**WEST SUSSEX COUNTY COUNCIL
STRATEGIC PLANNING CONSULTATION**

SUBJECT: LU/96/16/DOC - Application for approval of matters reserved by condition imposed under LU/47/11 relating to condition Nos. 5,7,8,10,11,12,13,14,15,21,22,23,24,25,26,30 & 31 - for units 6-117. Finishes, appearance,landscaping & layout, Design statement, Surface water drainage scheme, Access & maintenance of watercourse/culverts, Discharge of any flows to watercourses, Foul drainage strategy, Landscaping, Tree protection strategy, Construction method statement, Ecological management plan, Construction compound statement, Piling, Vehicle wheel cleaning facilities & highway cleaning strategy, Construction programme, Scheme for the location & installation of fire hydrants & Energy supply.

LOCATION: Land to the North of, Toddington Lane, Littlehampton.

This is the second WSCC highways and transport response to the above application following submission and review of additional information (received June/July 2016). It specifically responds to conditions 8, 22, 23, 25 and 26 of outline consent LU/355/10. Conditions 7, 10, 11, 12 and 13 (and any other areas where drainage advice is required) will require separate co

STANDARD COMPOUND LAYOUT

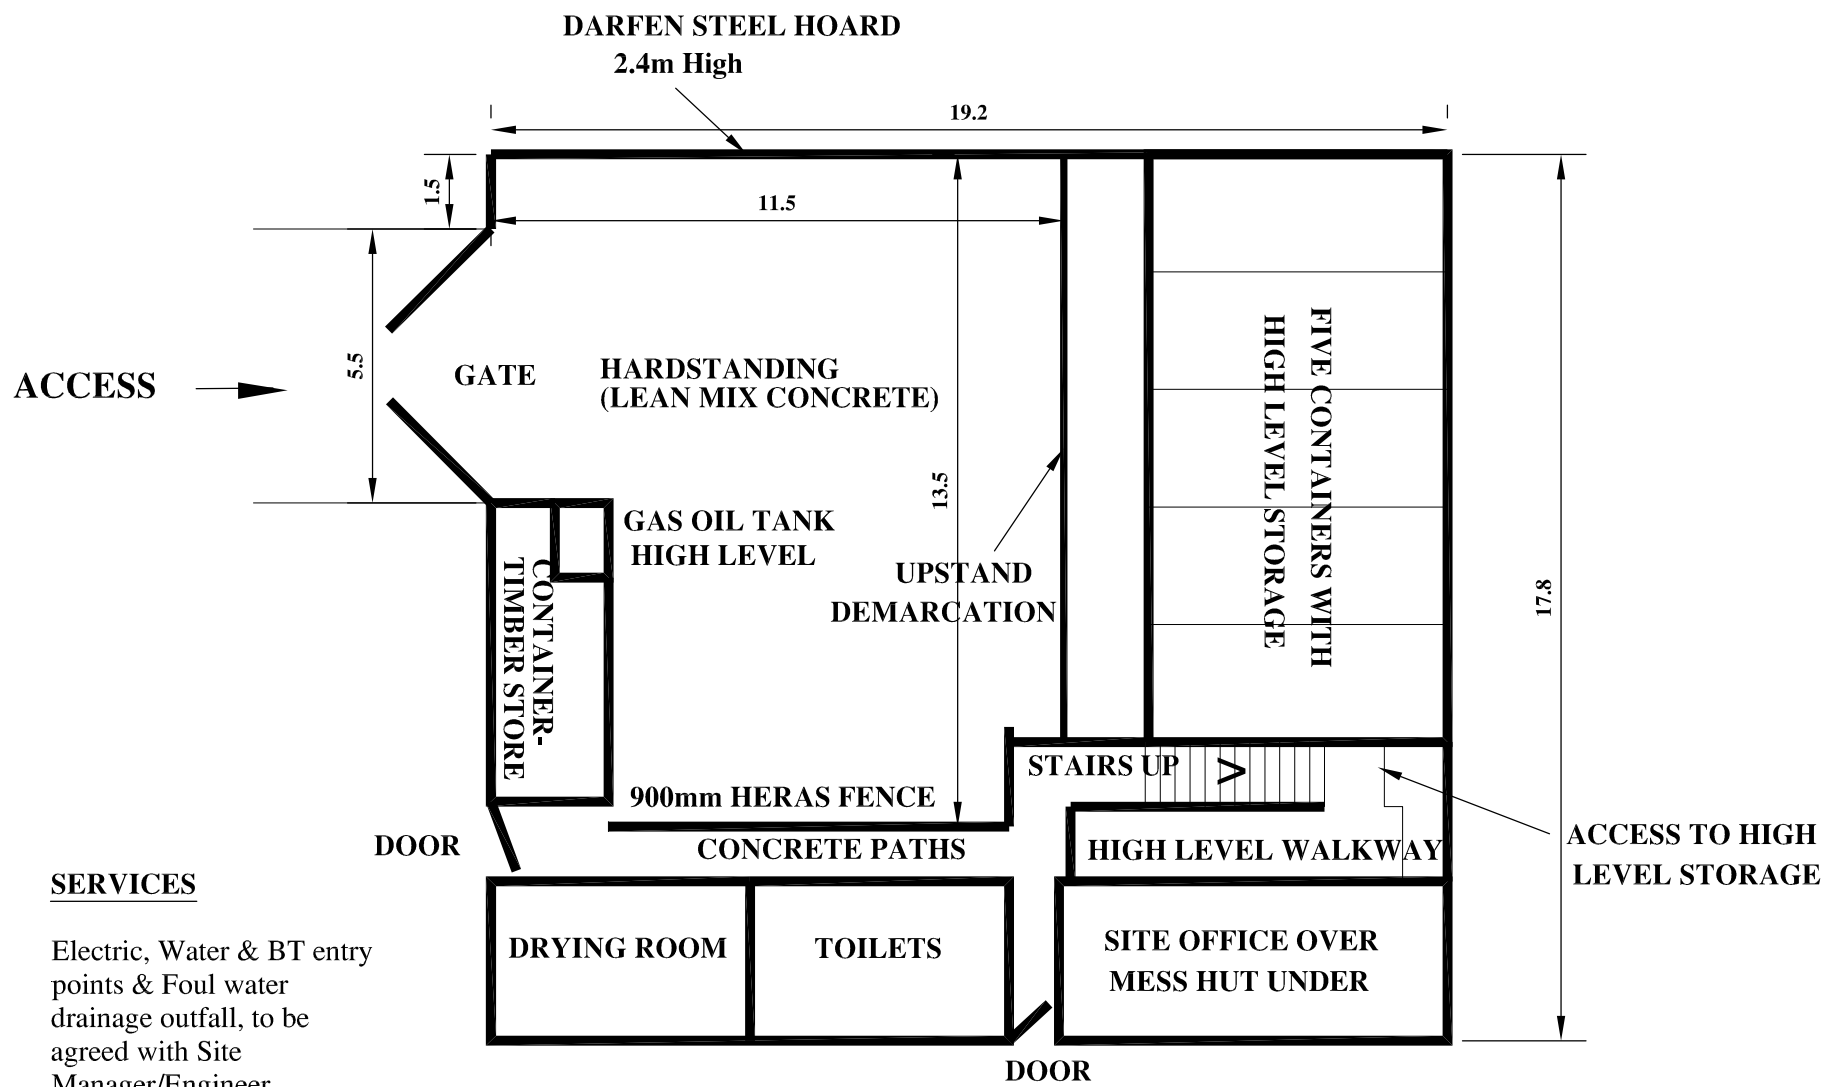
3. **Condition 23** – Construction compound details including details of turning facilities for delivery vehicles – Although a compound is shown on ‘Standard Compound Layout Plan’, it is not clear which location it relates to nor how vehicles would be able to turn around in or clear of it nor park. Also, it is not clear how access will be gained to the compound. Please provide a plan. **Now addressed/provided.**
